Current Zoning: N1-A (neighborhood 1, A)  
Proposed Zoning: N1-F(CD) (neighborhood 1, F, conditional)

The petition proposes to develop two triplex buildings and one quadplex on two parcels currently developed with two single family detached homes.

Staff recommends approval of this petition upon resolution of outstanding issues related to site design, environment, and transportation as well as a requested technical revision.

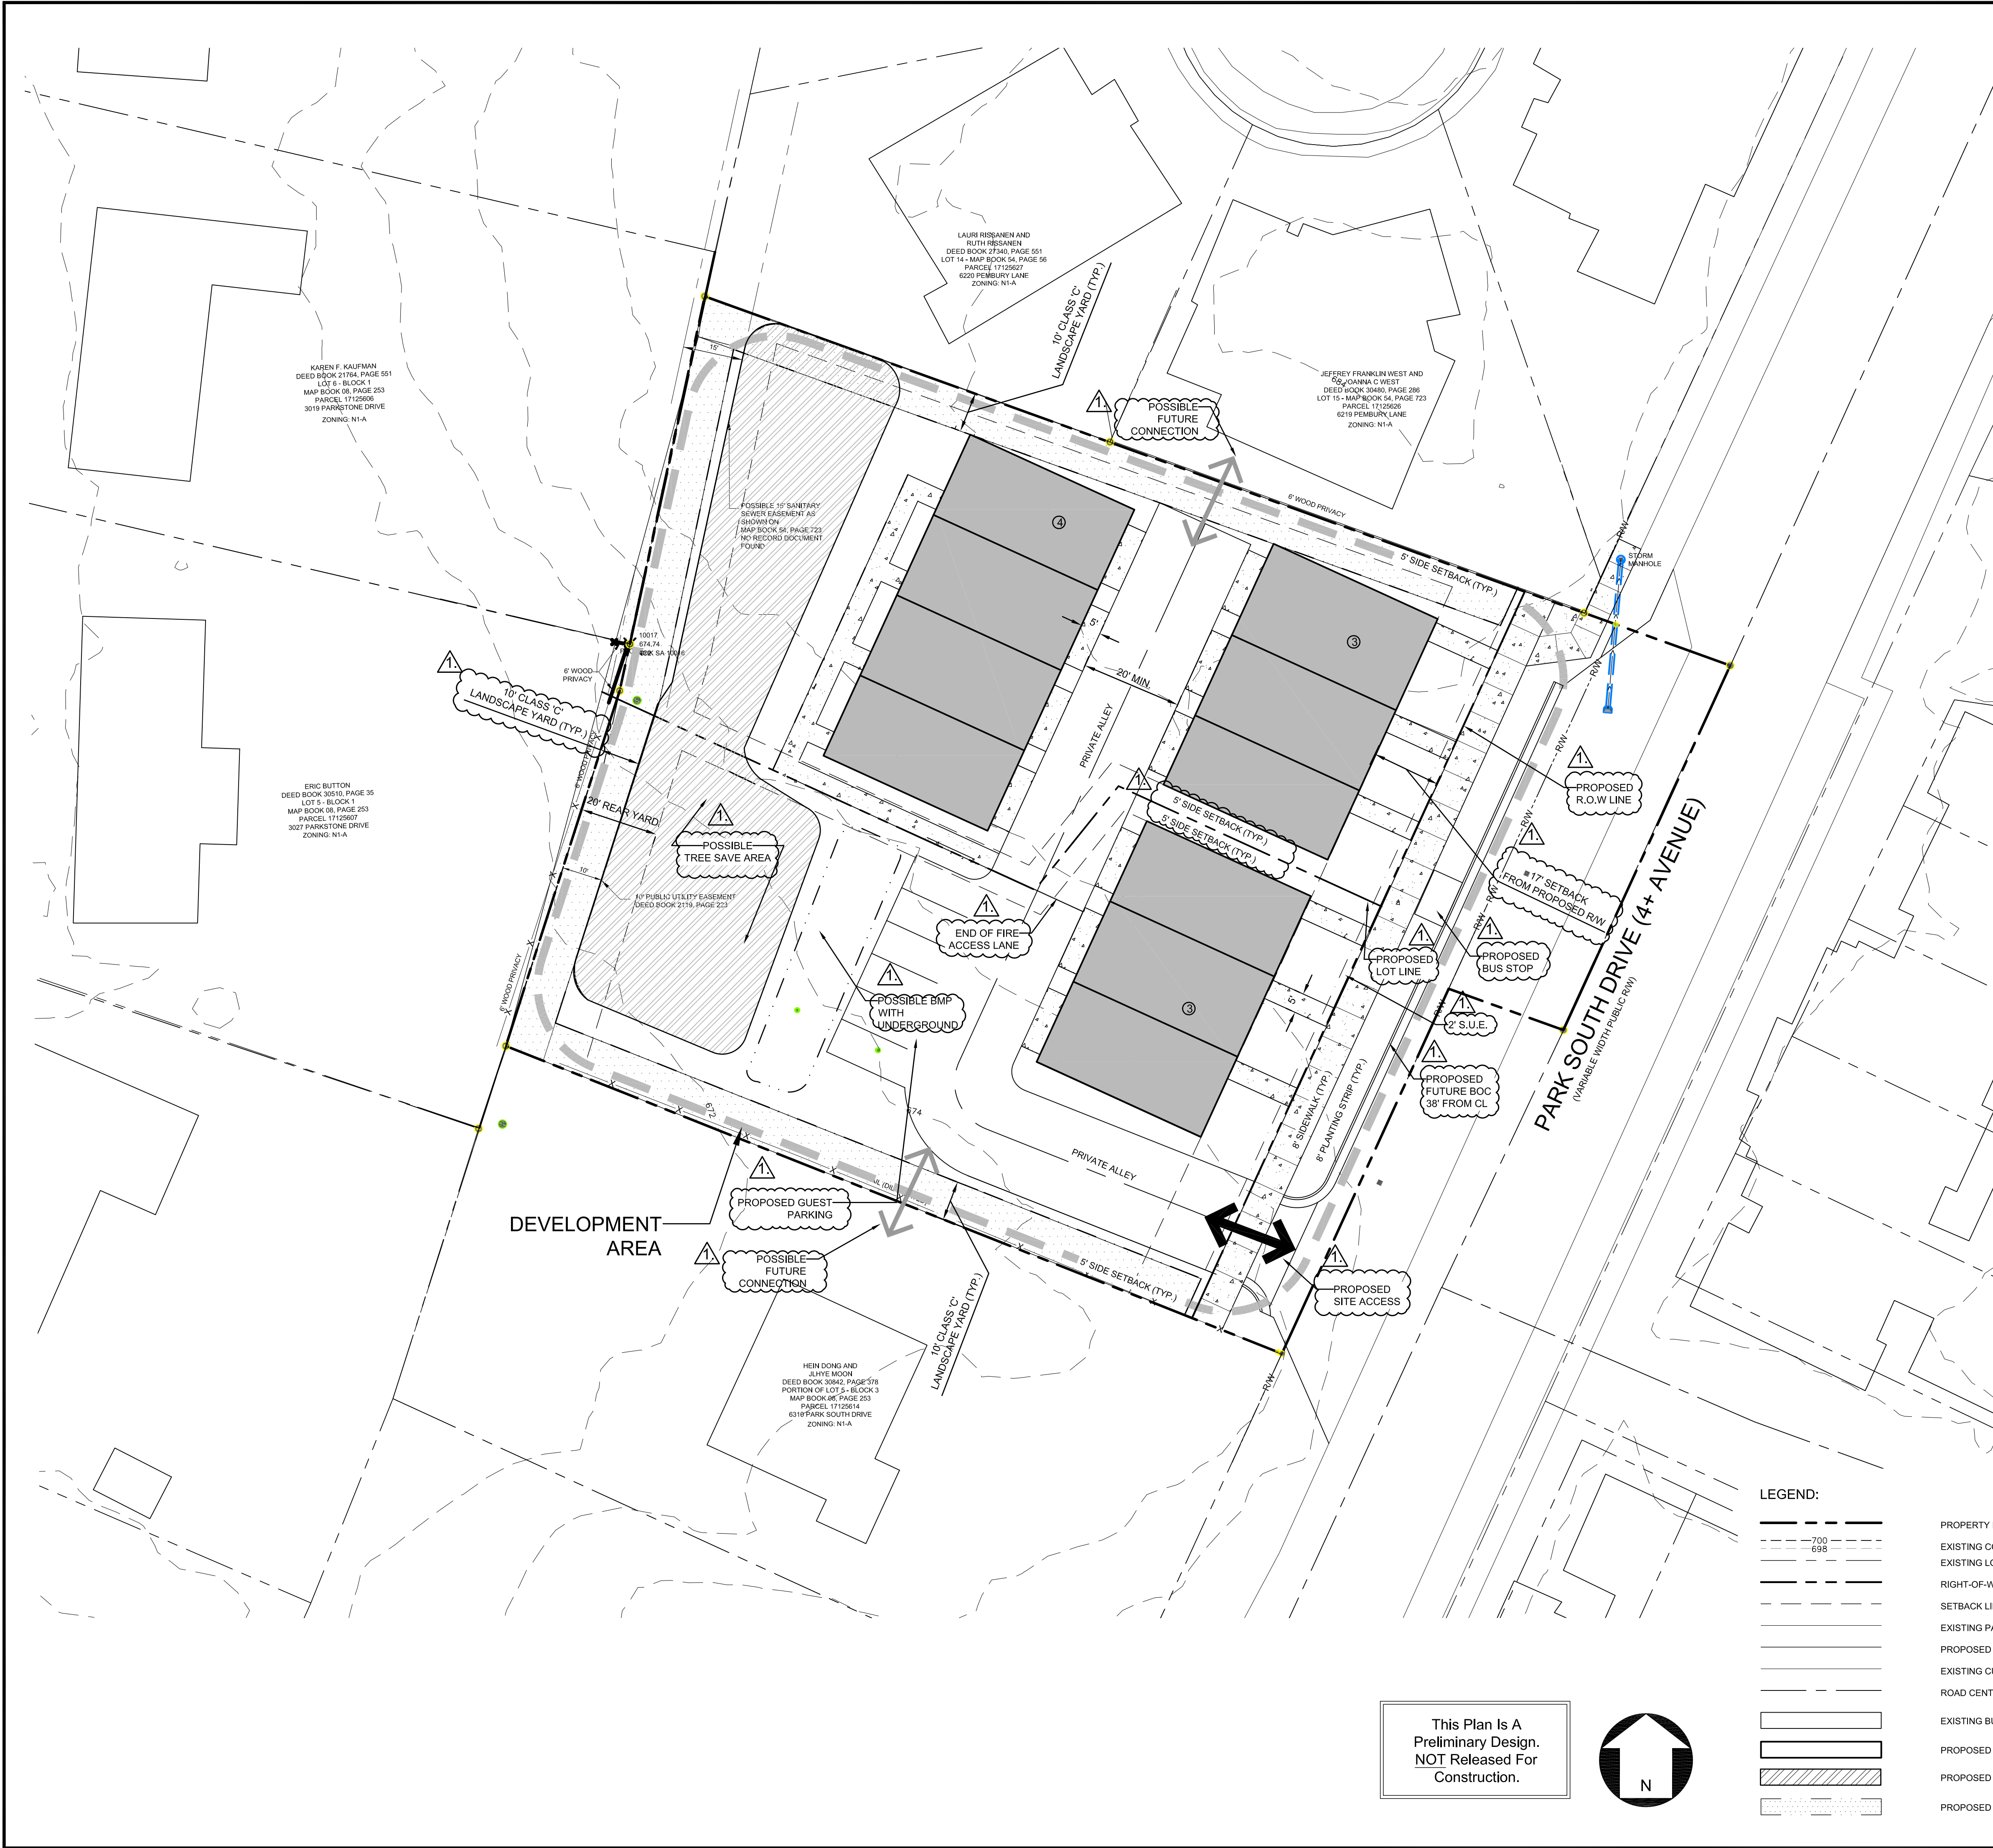
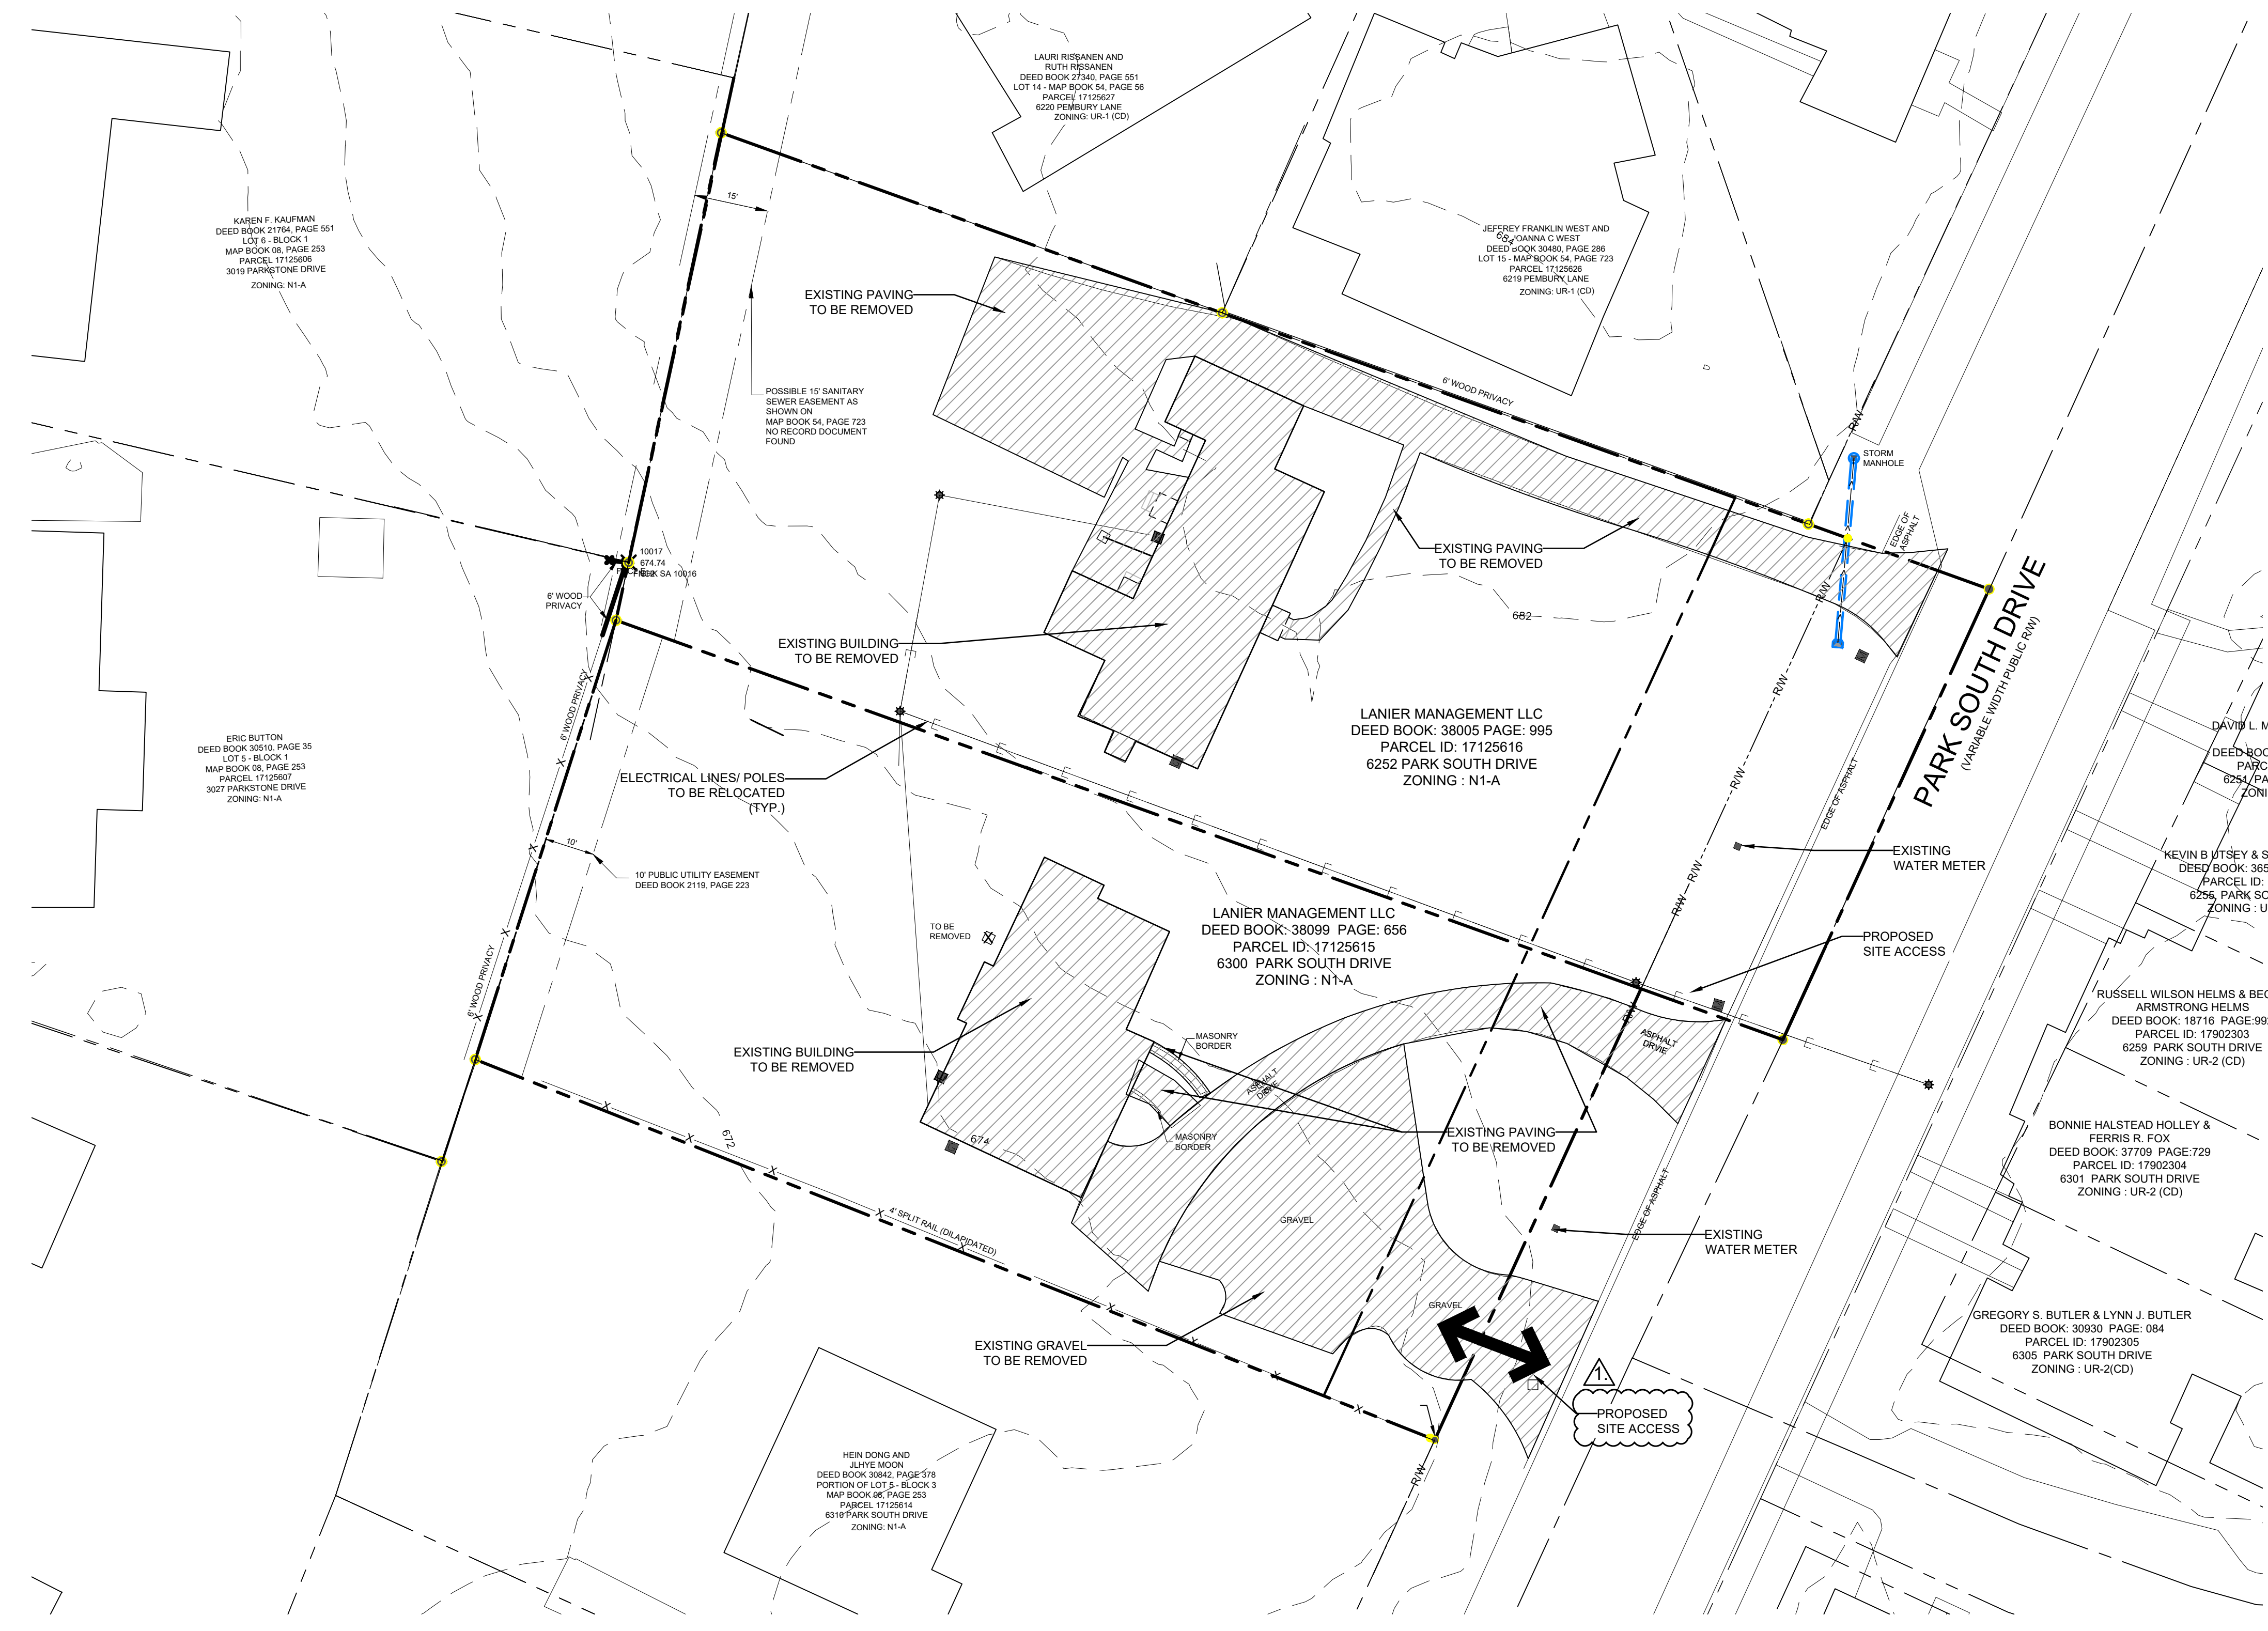
1. Revise the proposed driveways for the individual units to be compliant with Article 19.6.A.1.a of the UDO.

2. Clarify if the tree save area shown on the site plan is outside of the demolition plan.

3. The dimension for the proposed back of curb to the center line must be shown on the site plan as well as the buffered bike lane that is required per the Charlotte Streets Map cross section.

4. Revise conditional notes from note K in the transportation provisions to remove the wording, "as generally depicted on the site plan," since this commitment is not depicted on the site plan.
